**Mount Pleasant Coal Project (DA 92/97 MOD 4)
Request for Additional Information**

I am writing to seek additional information to inform the Department's continued assessment of the fourth modification application for the Mount Pleasant Coal Project (DA 92/97 MOD 4).

Engineering Drawings – Lighting Screens

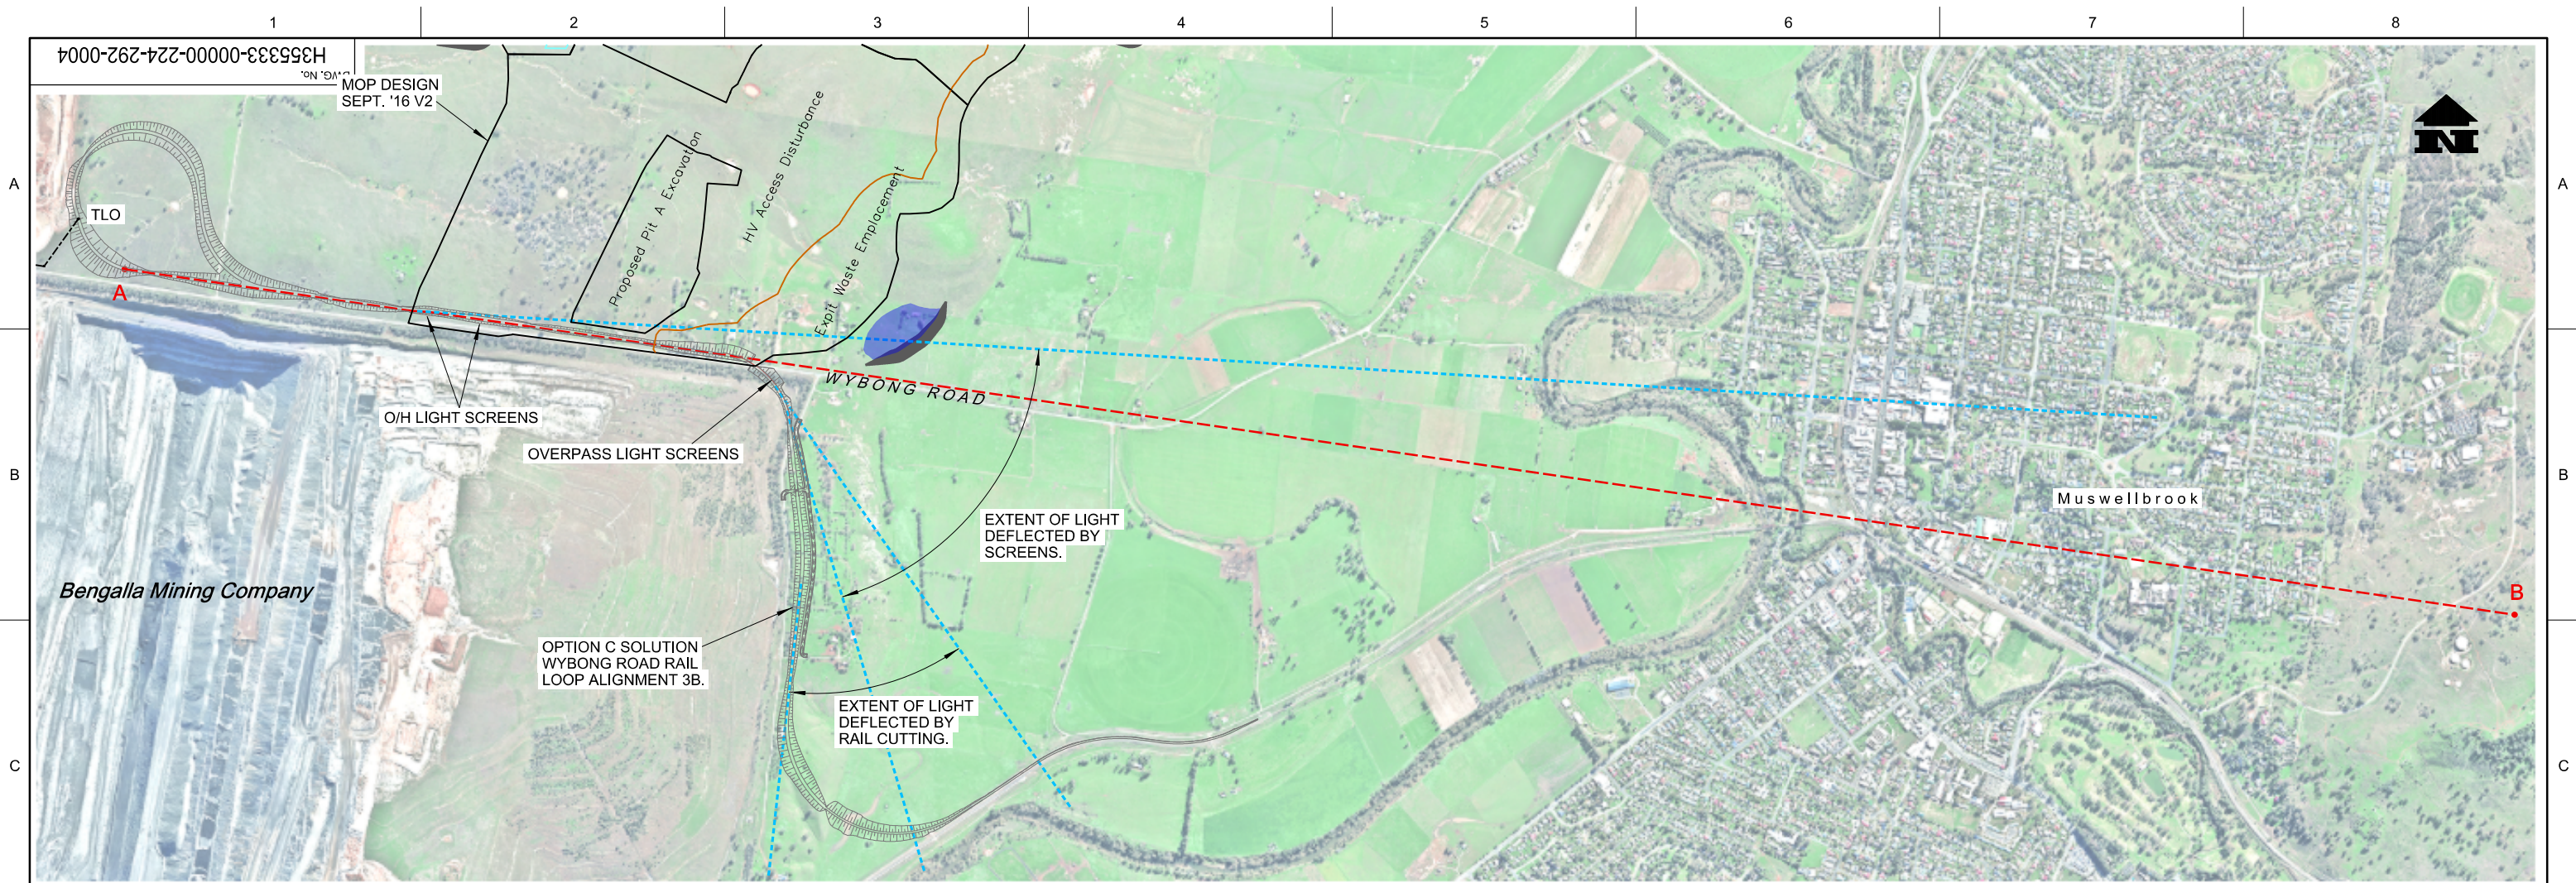
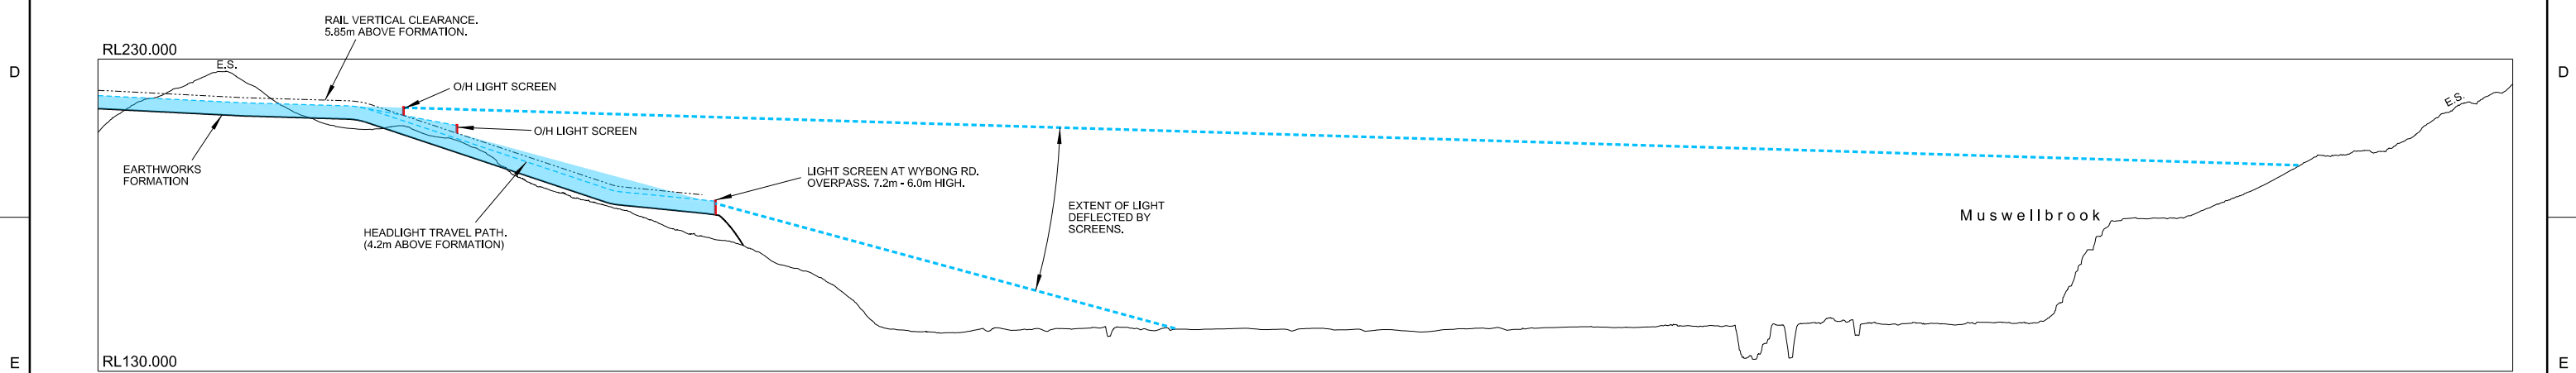
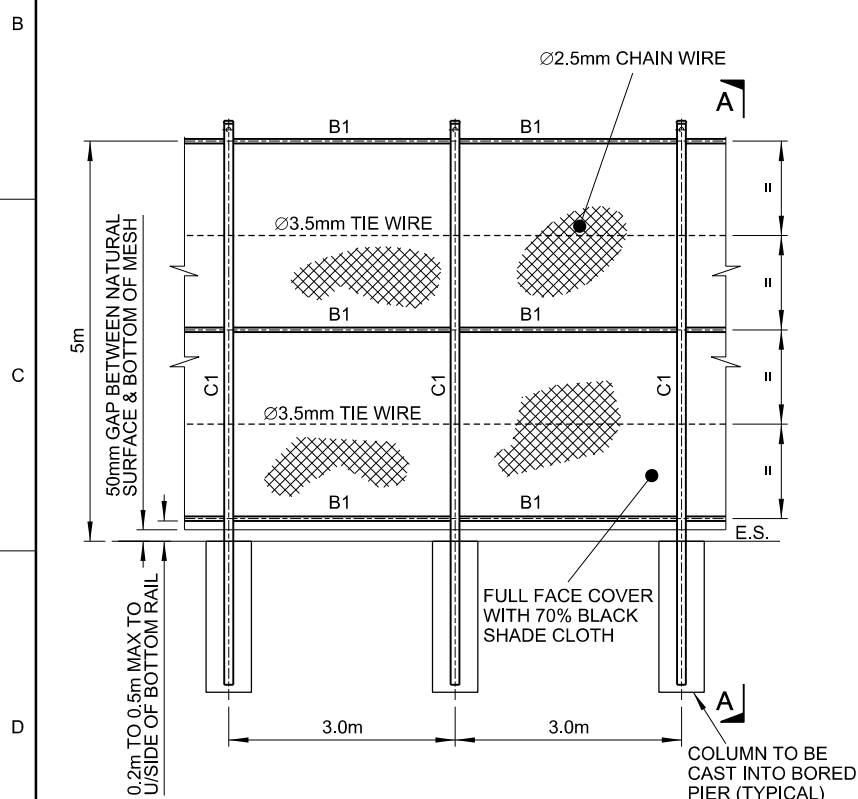
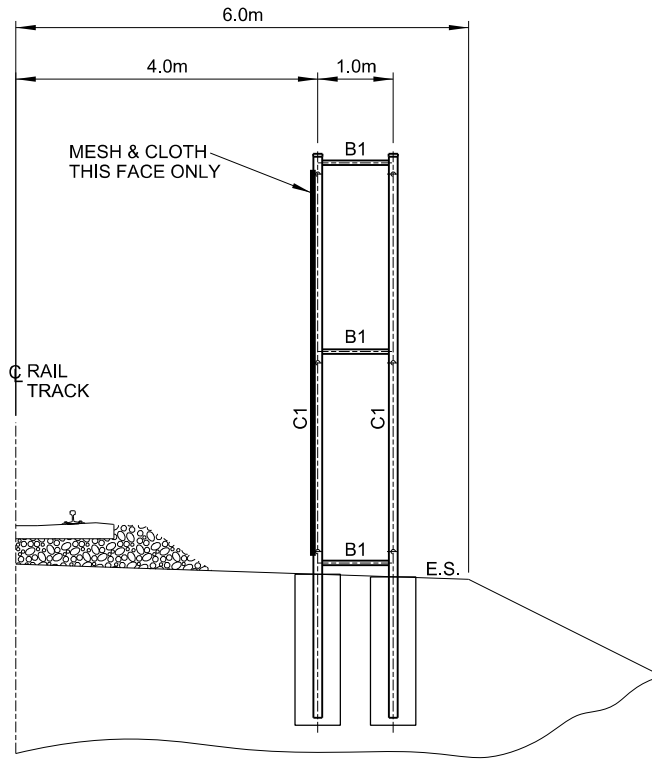
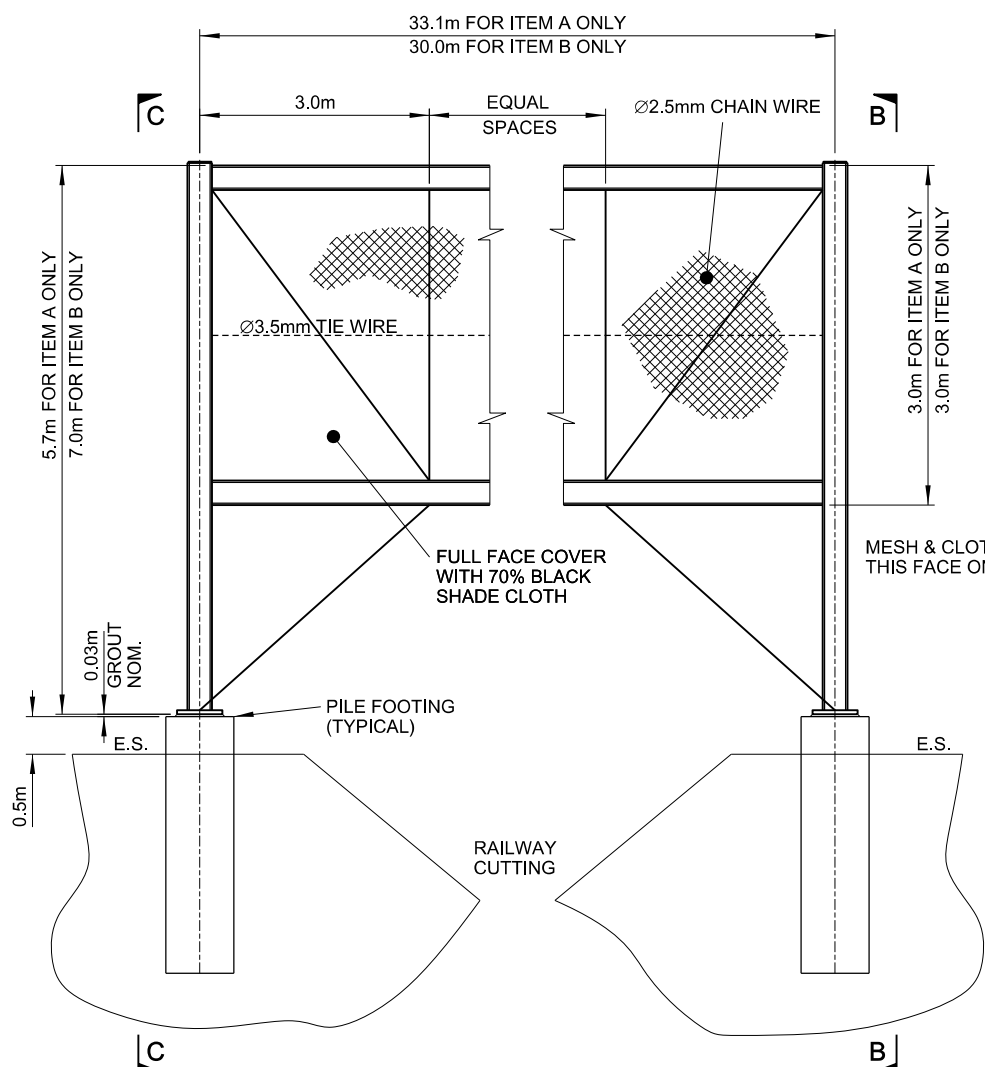
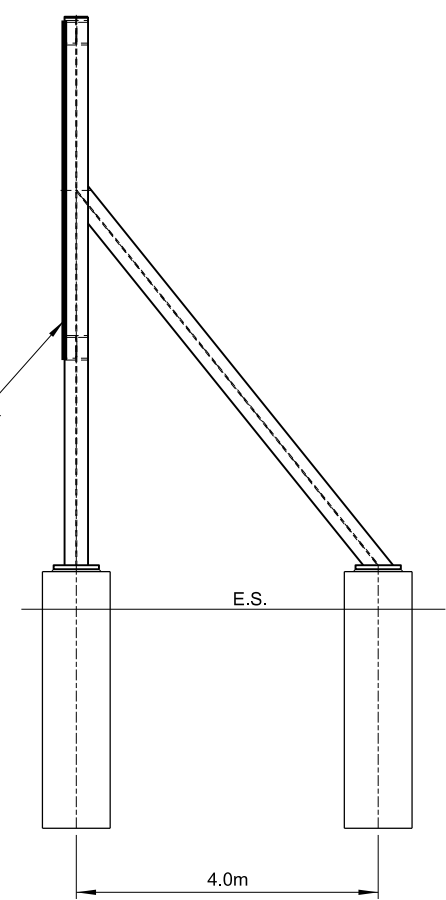
The EA and RTS identify that MACH Energy is proposing to construct visual bunding along Wybong Road and to construct three visual lighting screens over the rail spur, to mitigate the visual and lighting impacts of trains on road users and residents in Muswellbrook township.

In order to assess the efficacy of these proposed mitigation measures, please provide further information and figures demonstrating the directions and extent that train headlights travelling in an easterly direction would be visible to receivers.
